WEST SUSSEX COUNTY COUNCIL CONSULTATION

TO:	Arun District Council FAO: Kathryn Welch
FROM:	WSCC - Highways Authority
DATE:	17 June 2022
LOCATION:	The Riverbreeze Restaurant, 56-57 Pier Road, Littlehampton, BN17 5LP
SUBJECT:	LU/132/22/PD Notification for prior approval under Schedule 2 Part 3 Class MA for the change of use from Commercial, Business and Service (Use Class E) to 2 No. 1 bedroom ground floor apartments (Use Class C3).
DATE OF SITE VISIT:	N/A
RECOMMENDATION:	Advice
S106 CONTRIBUTION TOTAL:	N/A

SITE PLAN 1:500

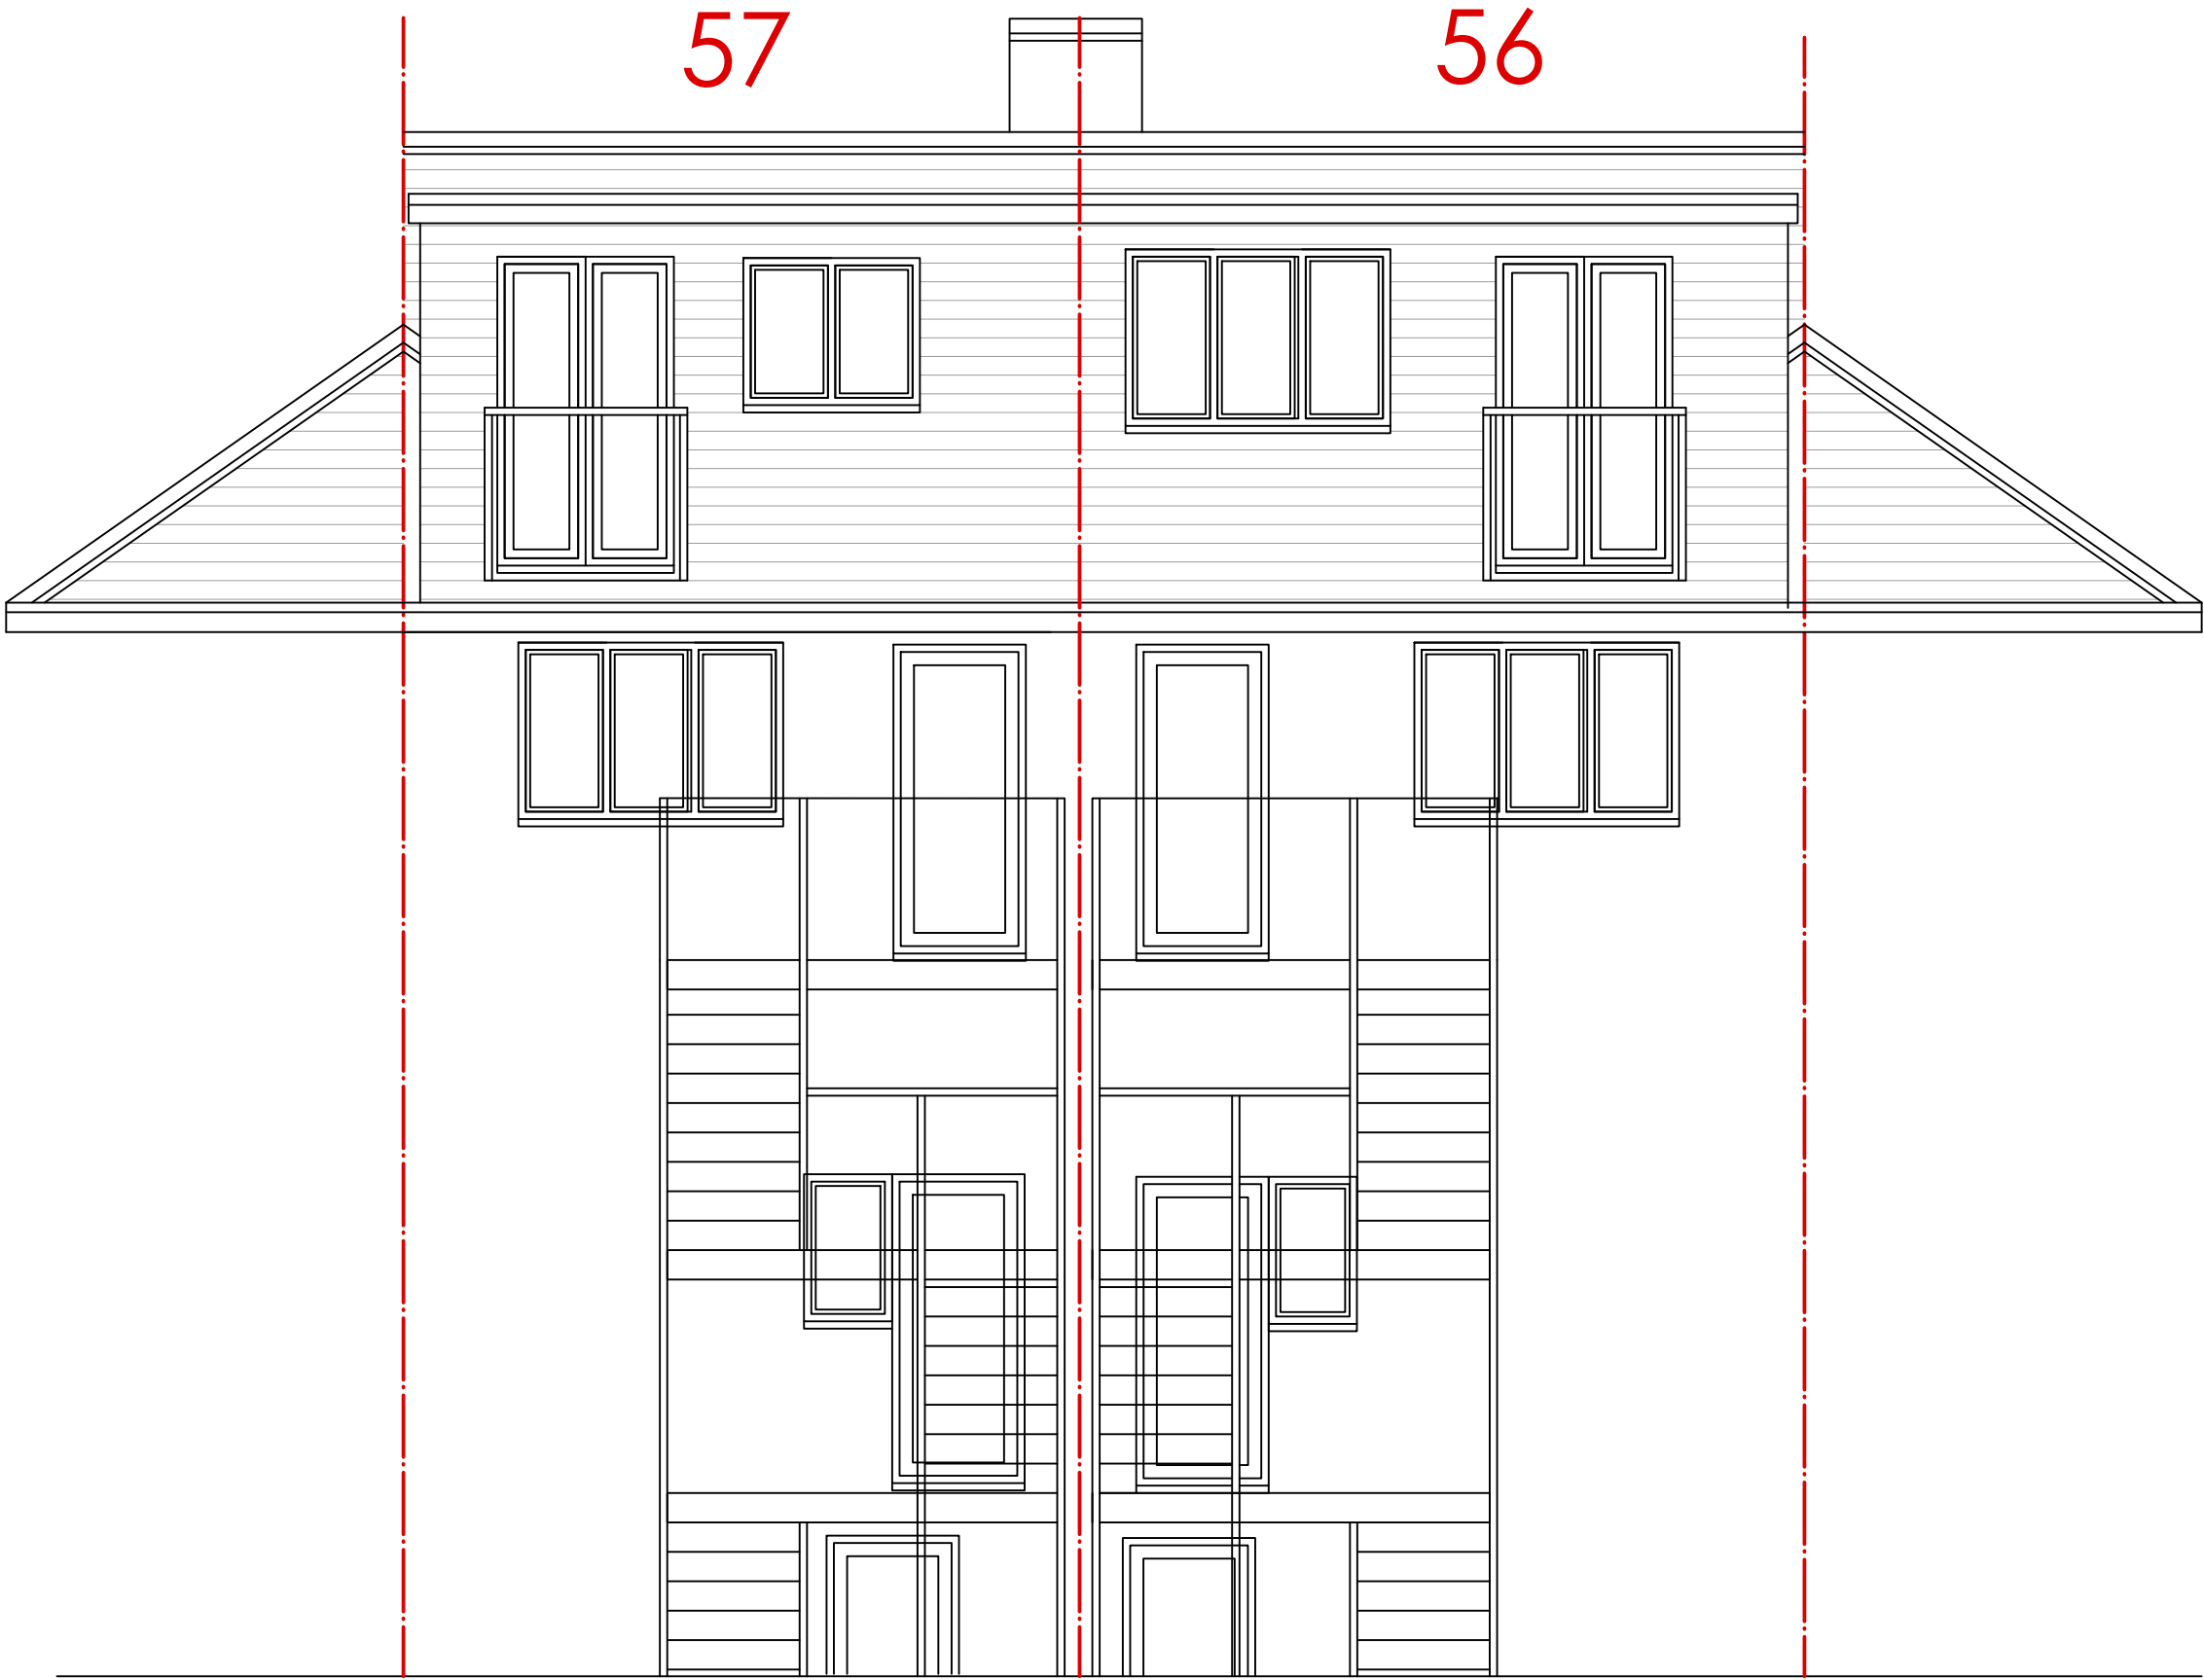
The prior notification process does not enable parking provision or other matters relating to accessibility to be considered. Nevertheless, under Arun Parking Standards, the LHA would expect a development of this size and location to provide two parking spaces. The applicant proposes two parking spaces to the rear of the site and as such, the LHA is satisfied with the proposed levels of parking provision.

The applicant has not demonstrated cycle parking provision. Cycling is a viable option in the area and the LHA would like to see secure and covered cycle parking provision being implemented if there is space within the site to accommodate this. The inclusion of cycle parking helps promote the use of sustainable transport methods.
